A personal response to Green Hill Solar Farm DCO application with particular reference to landscape and visual impacts around Easton Maudit. The author does not claim any planning expertise but has known, walked and loved this area for more than 30 years.

Date 6 Nov 2025.

Title: Figure 8.8.7 Bare Earth
Zone of Theoretical Visibility (ZTV)
of Full Scheme at Green Hill F

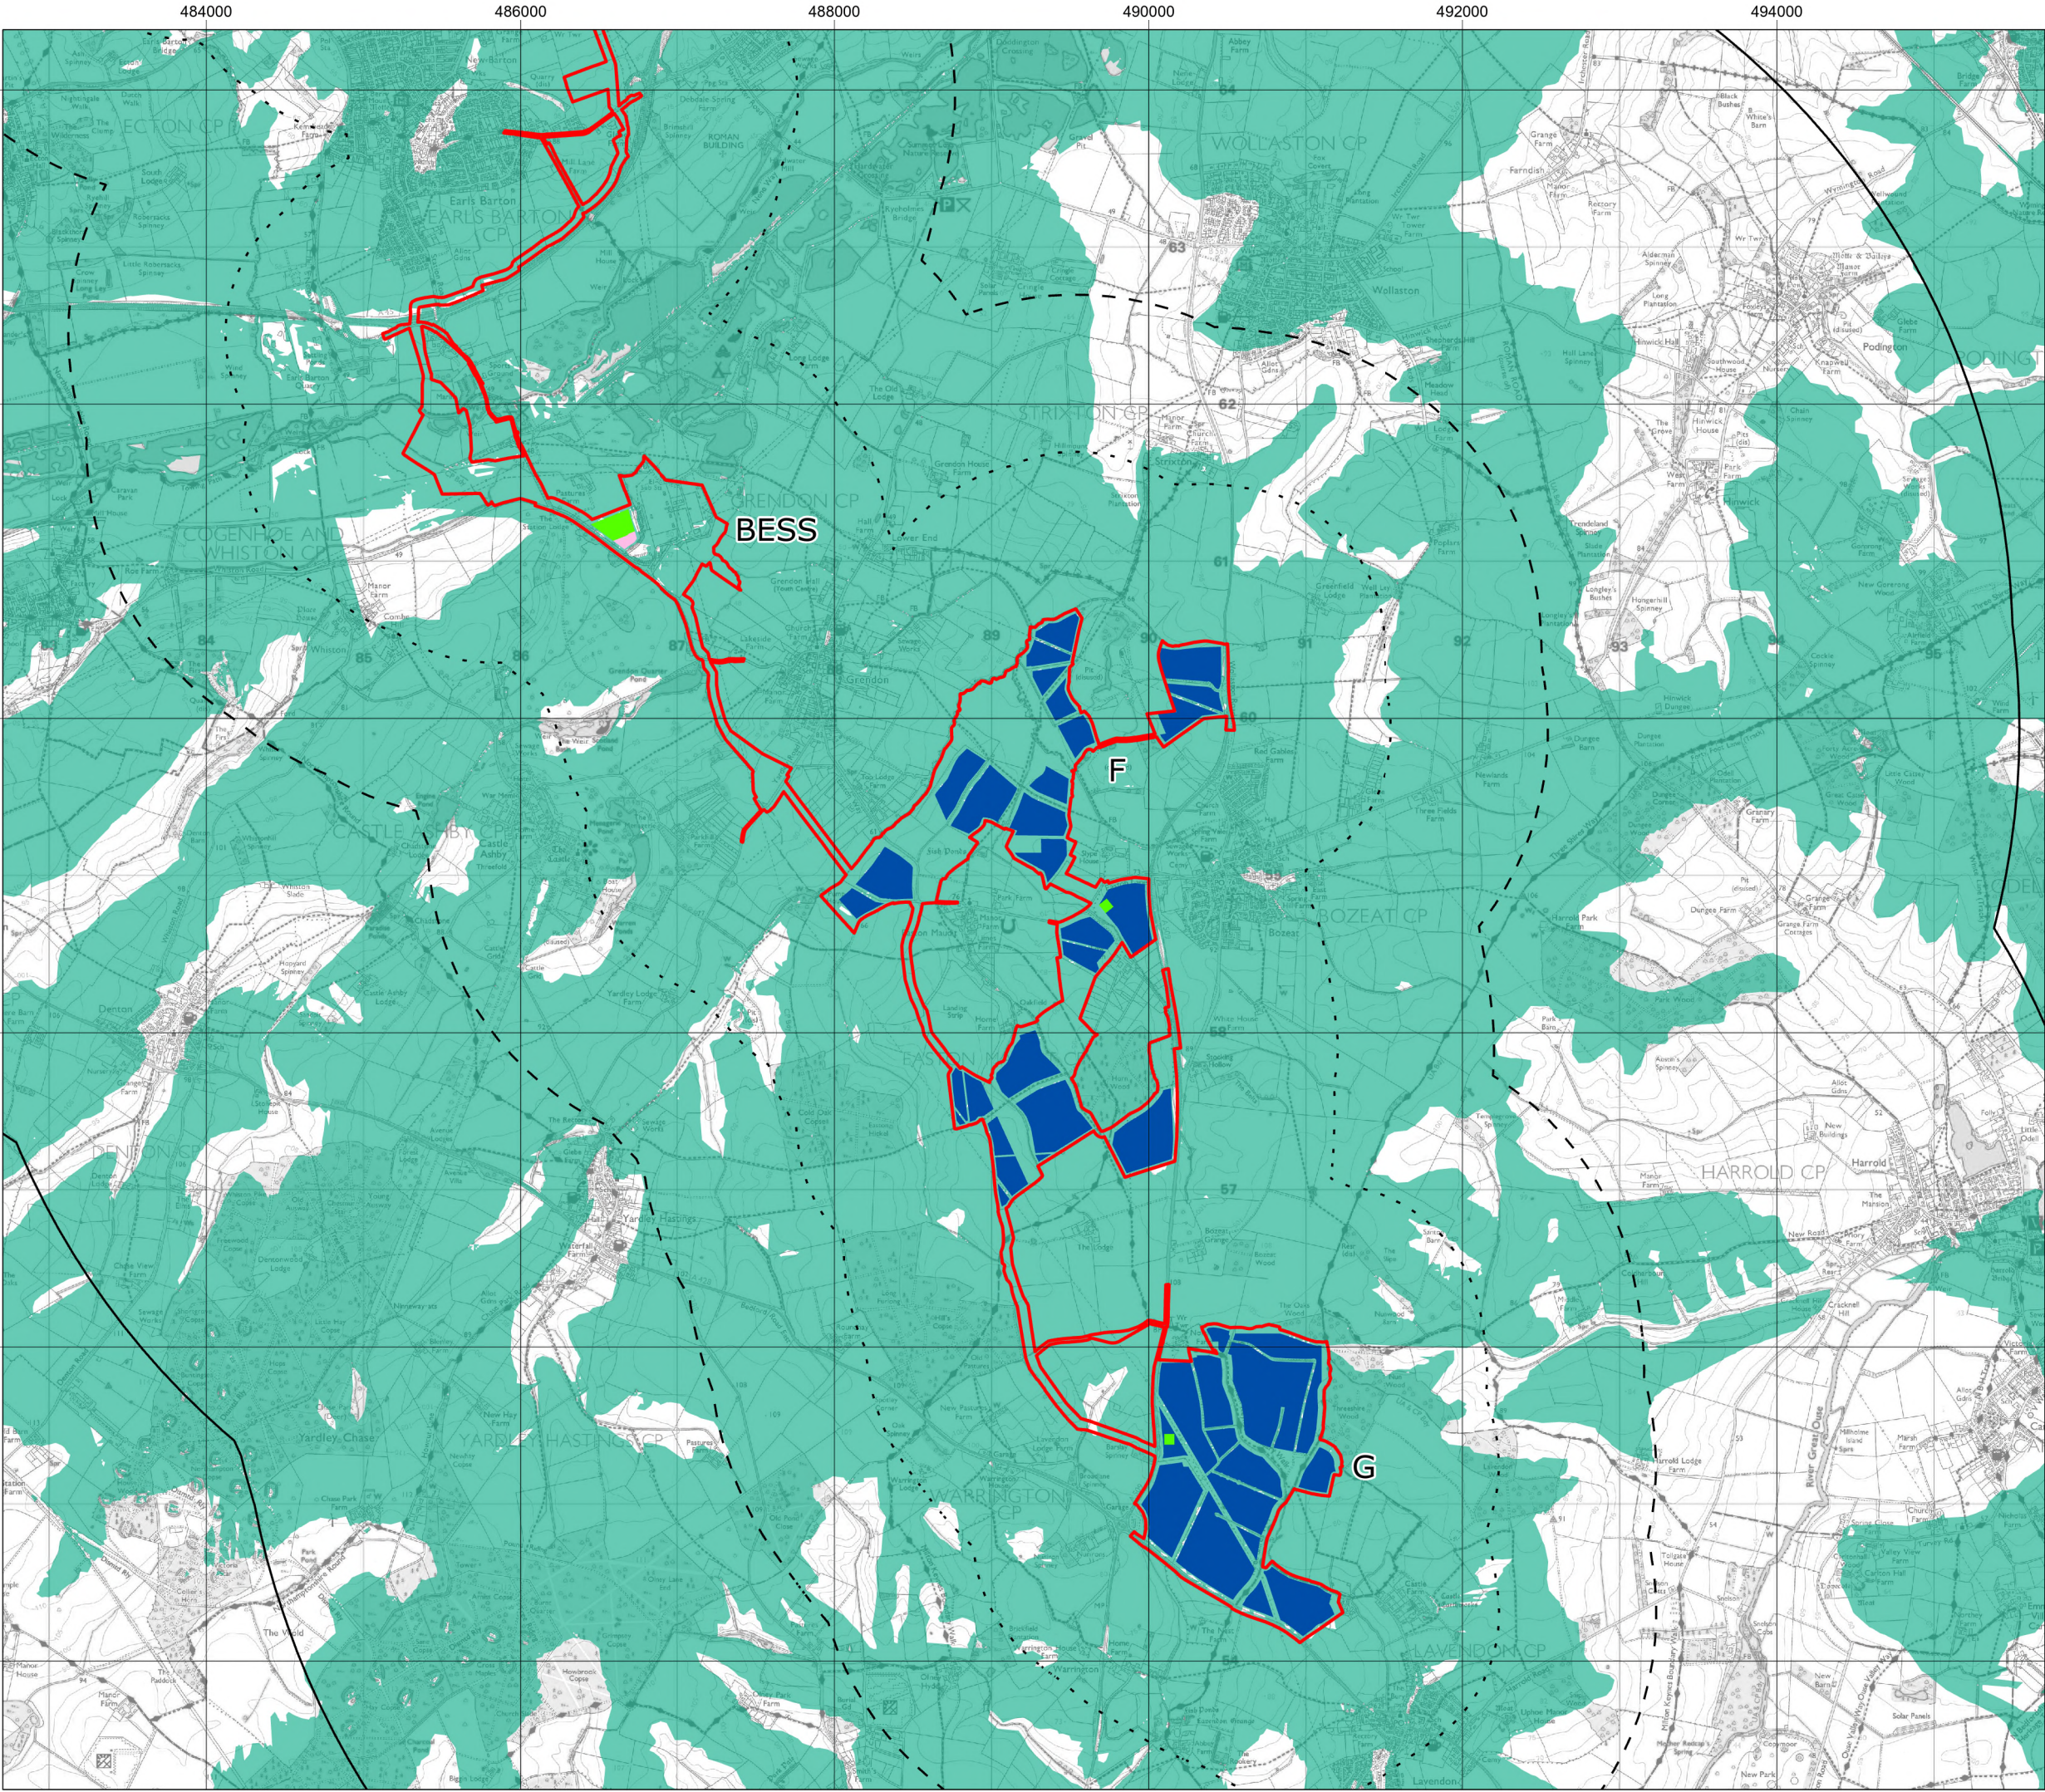
3. **Cumulative site effects.** As the PEIR shows in the bare earth and augmented ZTV projections (Multiple Figs. 8.8.1-8, 7.9.1-7 (incorrectly labelled as 7...), 8.9, 8.9.1-8), it will be difficult to avoid views of arrays and infrastructure over an extremely wide area whether on a public road, on foot or horseback. Access to and from Easton Maudit will necessarily involve passing alongside fields of PV arrays which will be visible simultaneously in the middle and further distance. As far as I can determine from the augmented ZTV projections, a drive of 32km from Lavendon to Old, via Easton Maudit and Grendon, taking as straight a course as possible, would necessitate seeing solar arrays and infrastructure for virtually the entire 40 minute journey, and even further north as far as Lamport and Mawsley. The *cumulative site effect* of this will be highly detrimental (see PEIR paras 8.4.67-68).
